REQUEST

Current Zoning: N1-A (neighborhood 1-A)
Proposed Zoning: CG(CD) (general commercial, conditional)

Approximately 3.85 acres located at the southwest intersection of Oakdale Road and Mt. Holly-Huntersville Road, north of Interstate 485.

The petition proposes a neighborhood shopping center with up to 31,500 square-feet of commercial/retail space as allowed in the General Commercial Zoning District.

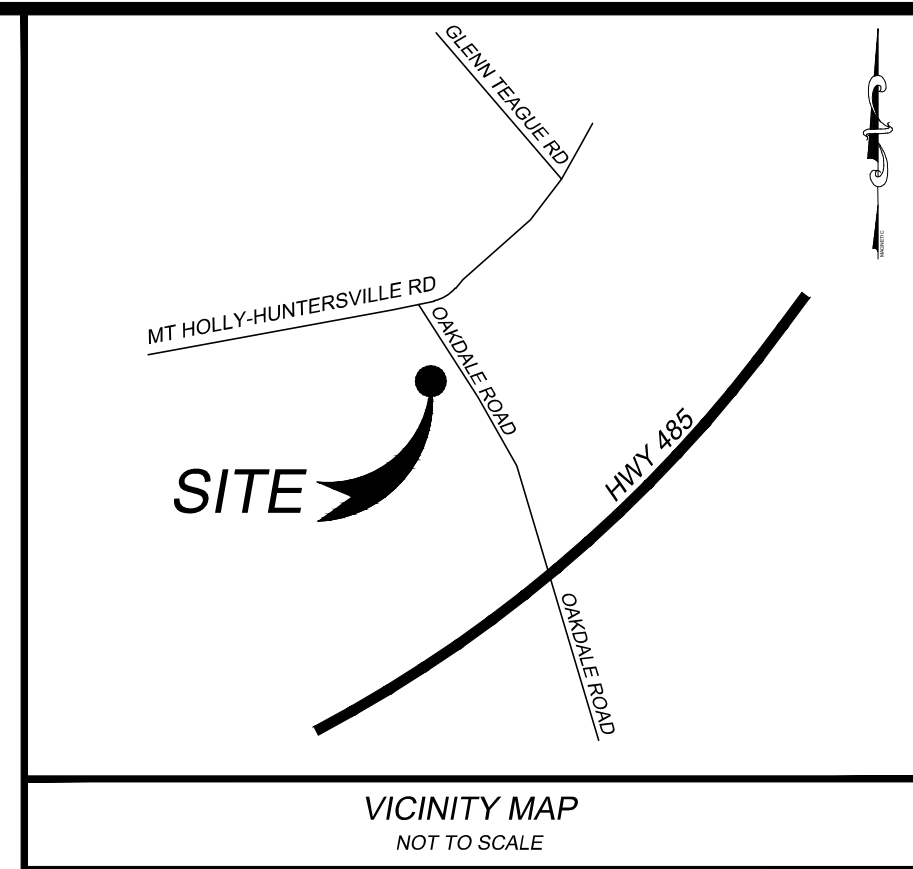
1. Complete CTR summary table and include on the revised plan.

2. Tree save needs to be shown on the plans in a way that meets the ordinance. Tree save must be comprised of existing protected tree canopy.
